Application No: R/253/20/HH  
Site Address: 33 Knightscroft Avenue Rustington BN16 2HW  
Description of works: Single storey annex building ancillary to main dwelling.

My Council has re-considered this application and would like to rescind its previous submission to raise no objection (letter dated 22 December 2020 refers), and instead, wishes to object to it on the following grounds:-

PROPOSED PLAN 1:100

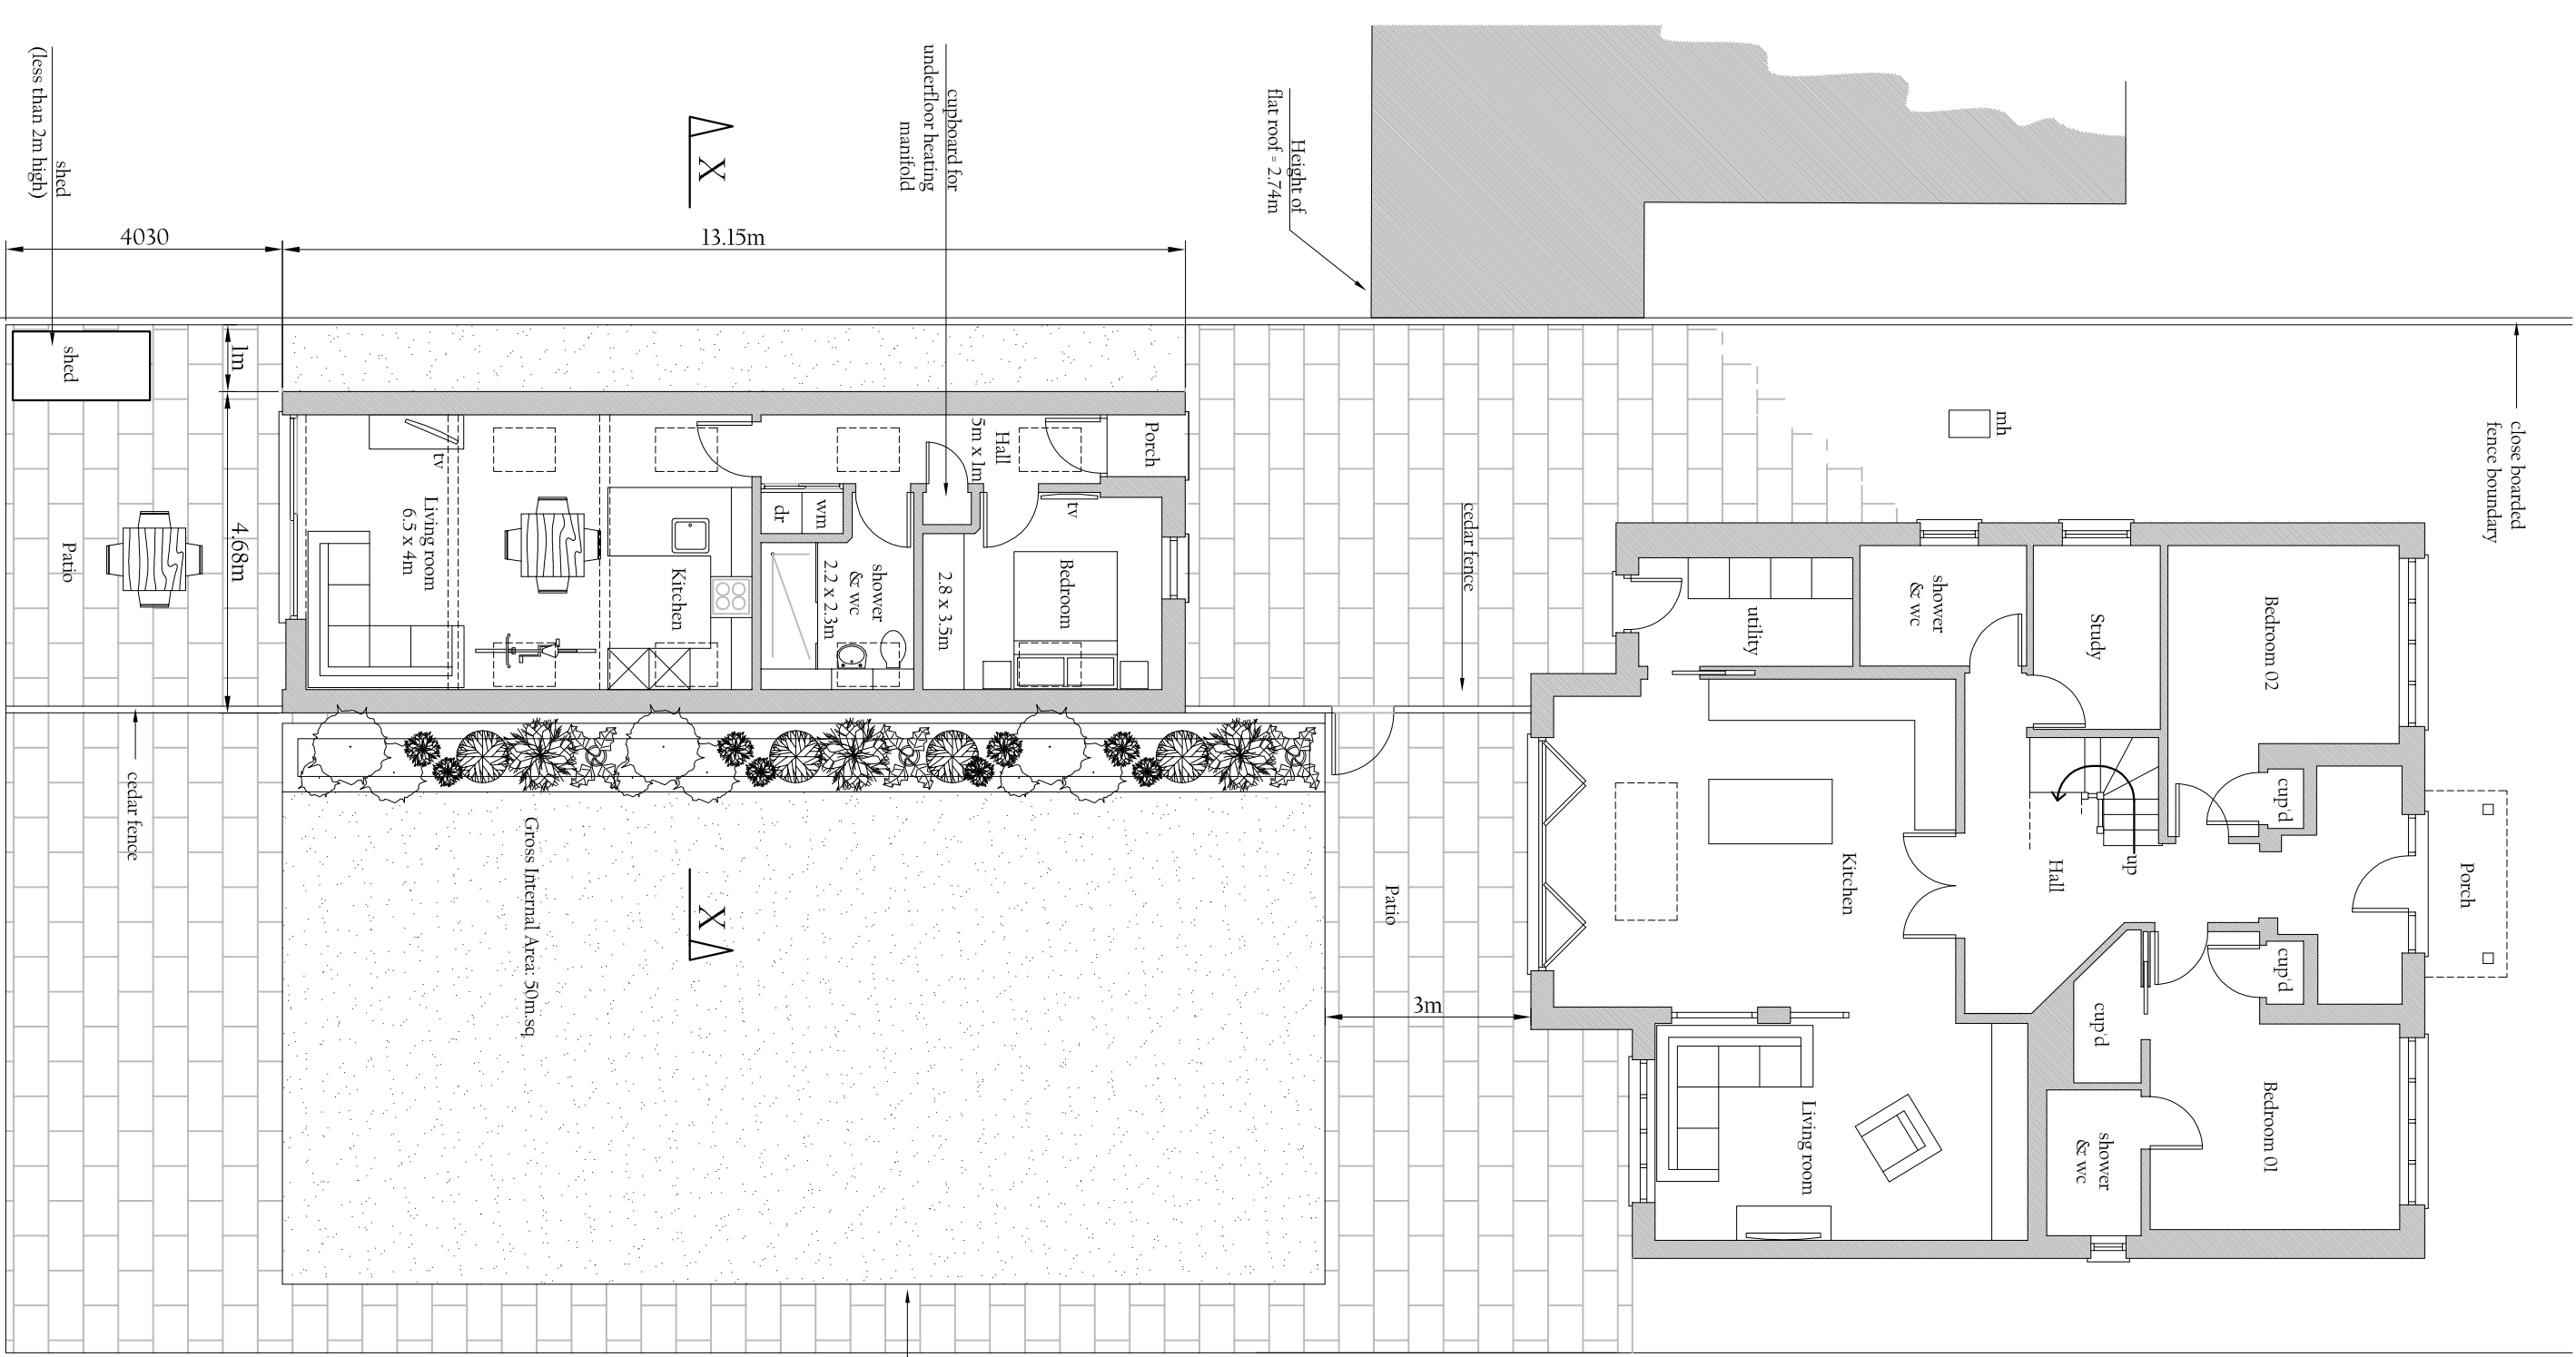
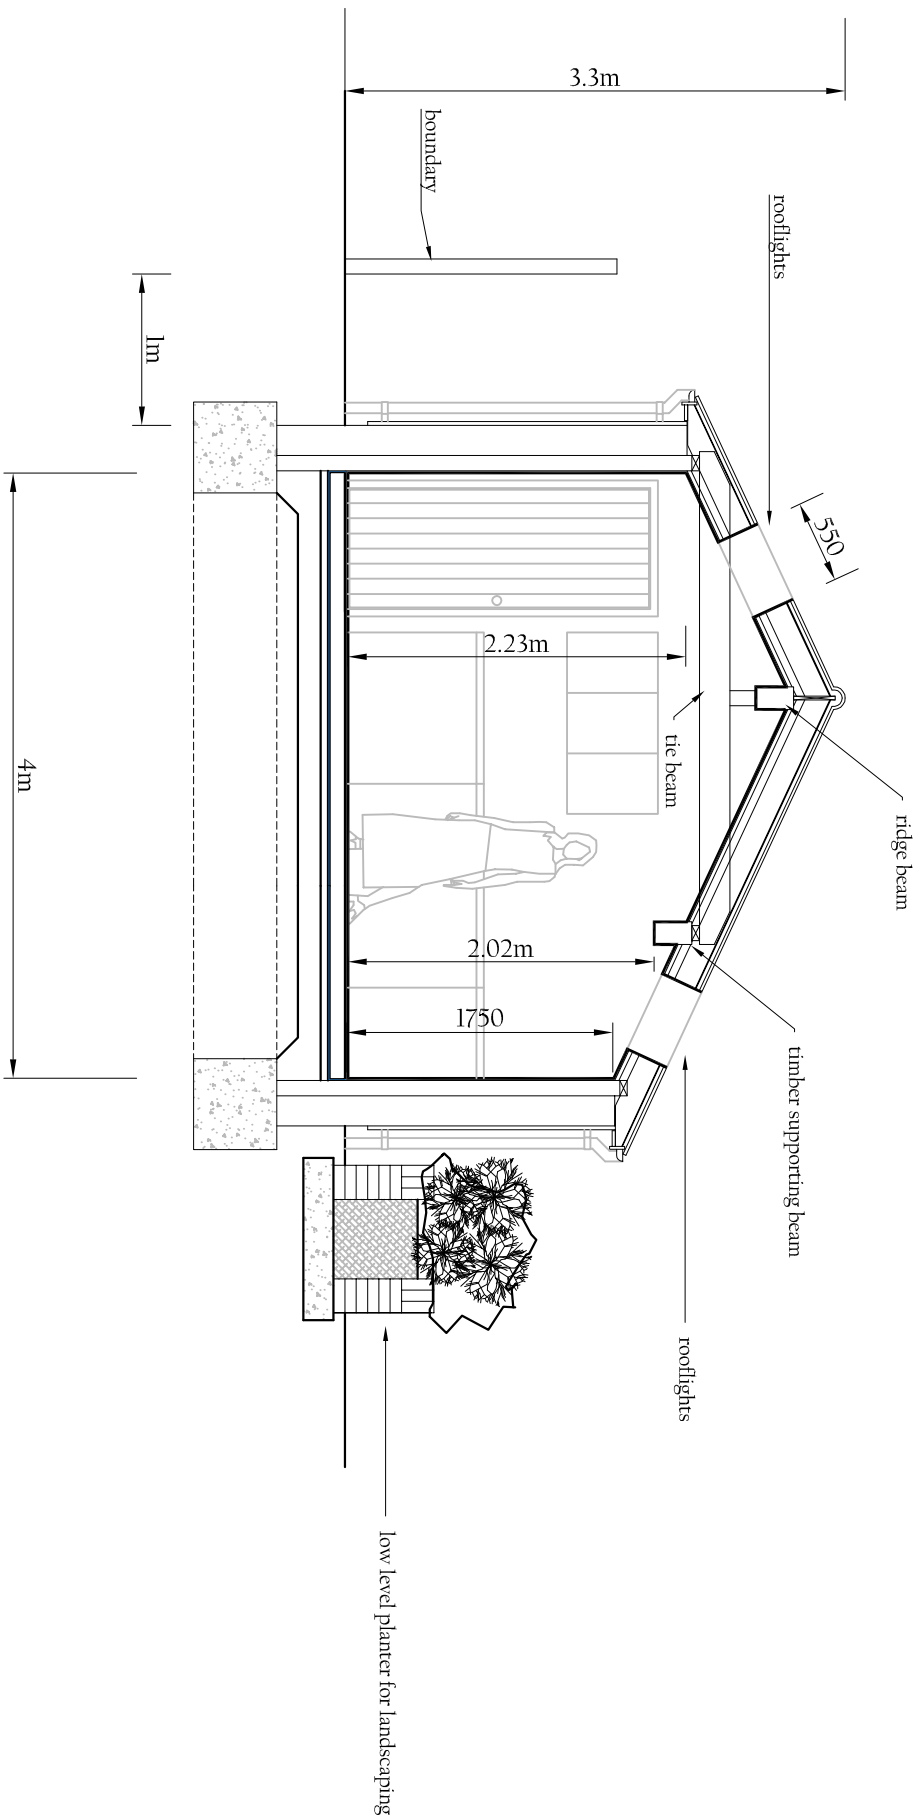
- (i) The proposal for a single storey annex of over 13 metres in length, would span almost one complete side of the back garden, and would most certainly represent an overbearing impact on the neighbouring property, namely No. 35 Knightscroft Avenue
- (ii) The proposal would have an adverse effect on the privacy, visual amenities and quiet enjoyment of the occupier/s of the aforementioned neighbouring property
- (iii) The proposal, by reason of its mass, would represent an over-development of the site
- (iv) The proposal for an additional living space could increase the vehicular movement in close proximity of No. 35 Knightscroft Avenue, and would also result in an increase in pedestrian footfall along the eastern boundary of that property.
- (v) The proposal would be in conflict with Policy 2 of the Rustington Neighbourhood Plan (mass and overbearing impact).
